# KITTITAS COUNTY COMMUNITY DEVELOPMENT SERVICES

Subject: Curry Boundary Line Adjustment (BL-14-00022)

BL 14-00022  
 Current line: 104636  
 Est of Douglas Curry

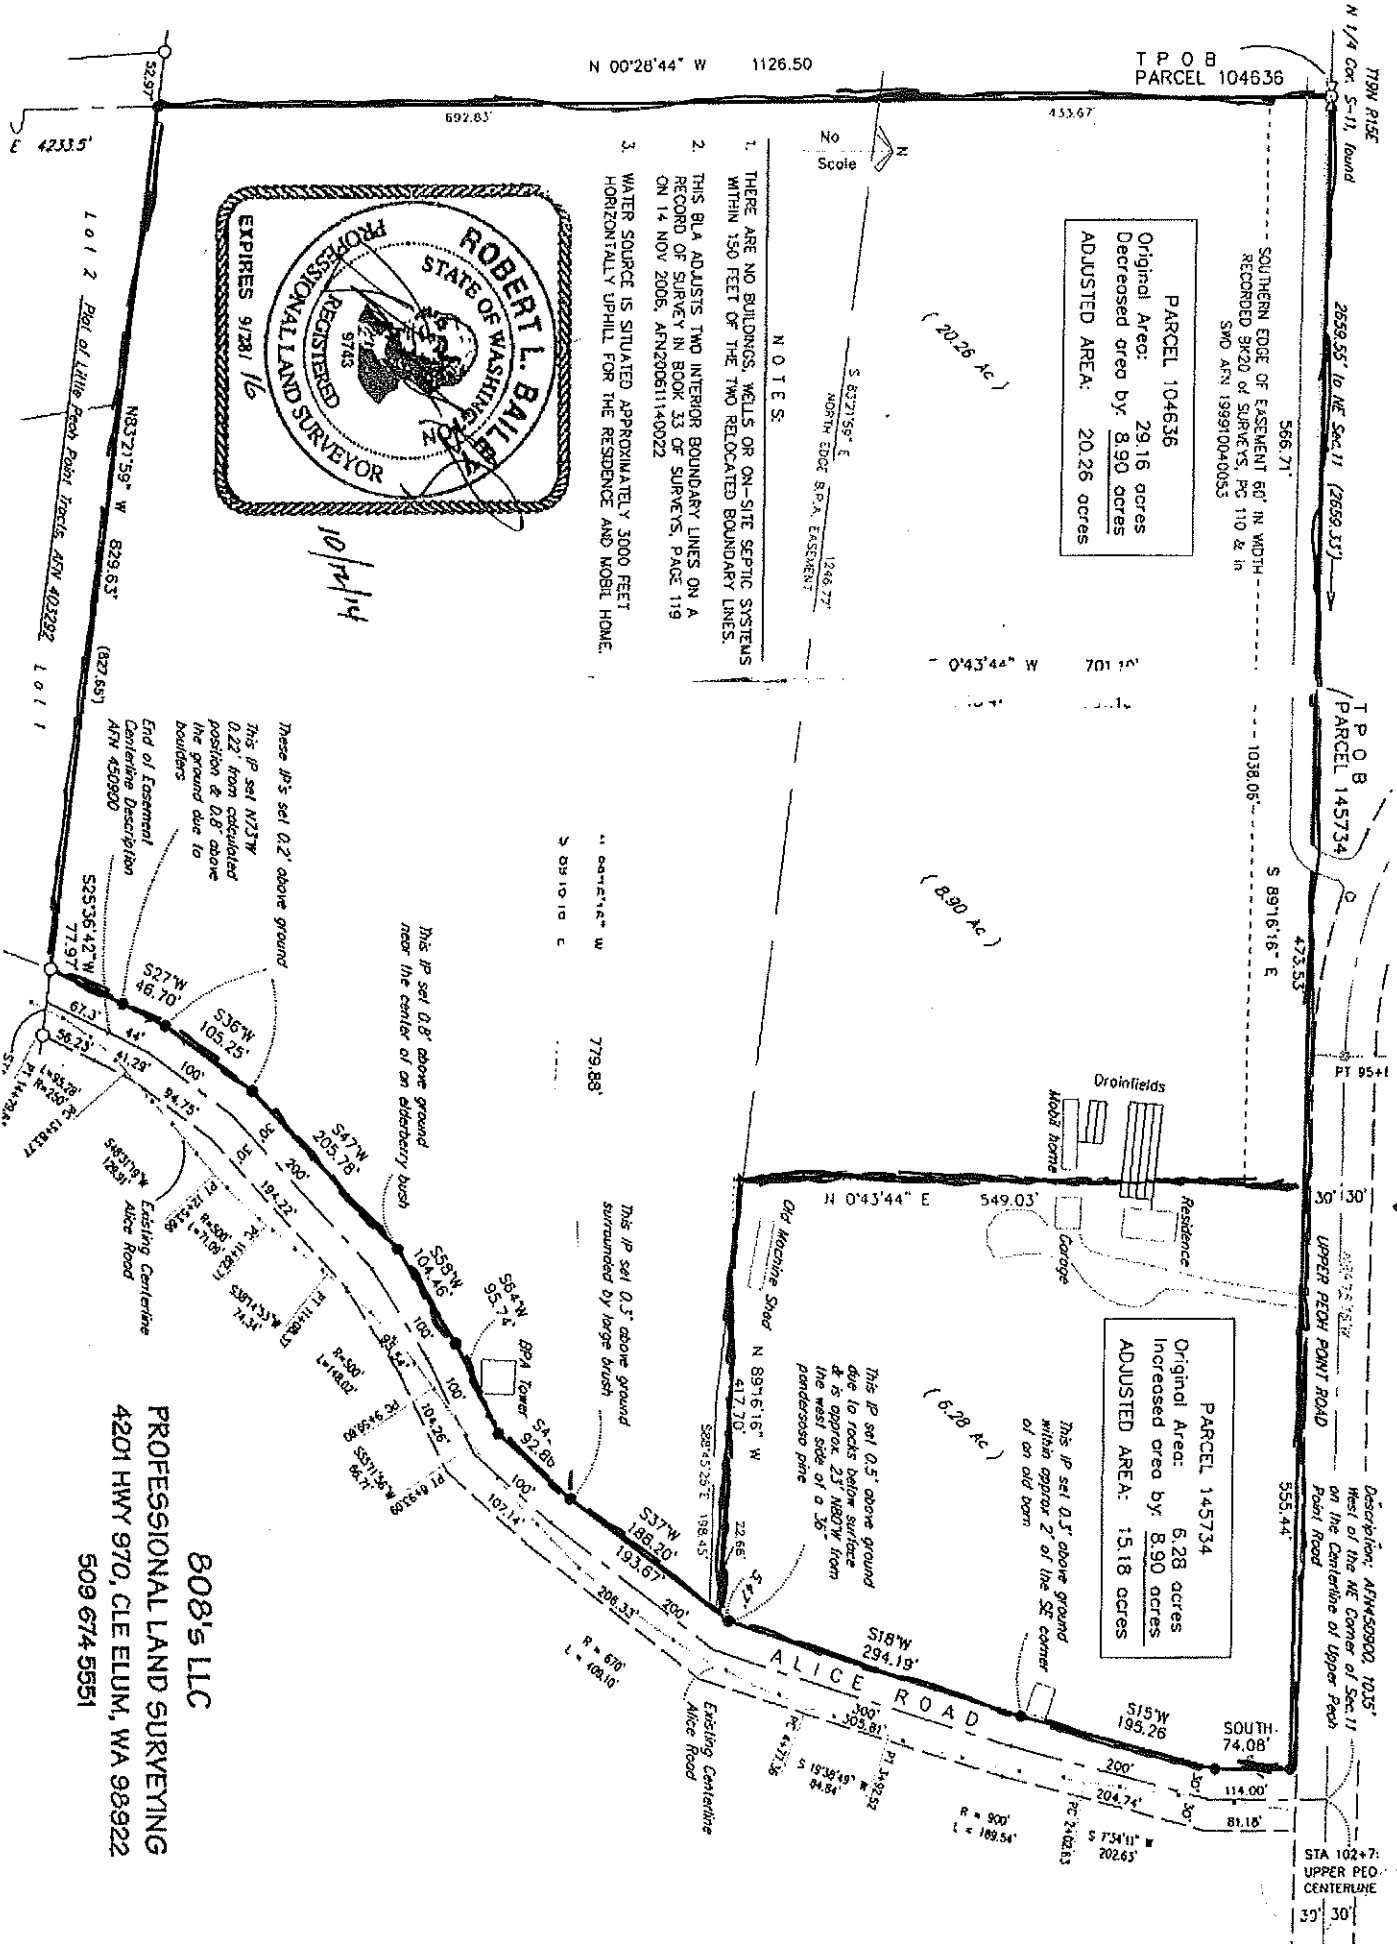
- ***Location of Septic and Wells on all parcels associated with Boundary Line Adjustment on an existing site plan.***
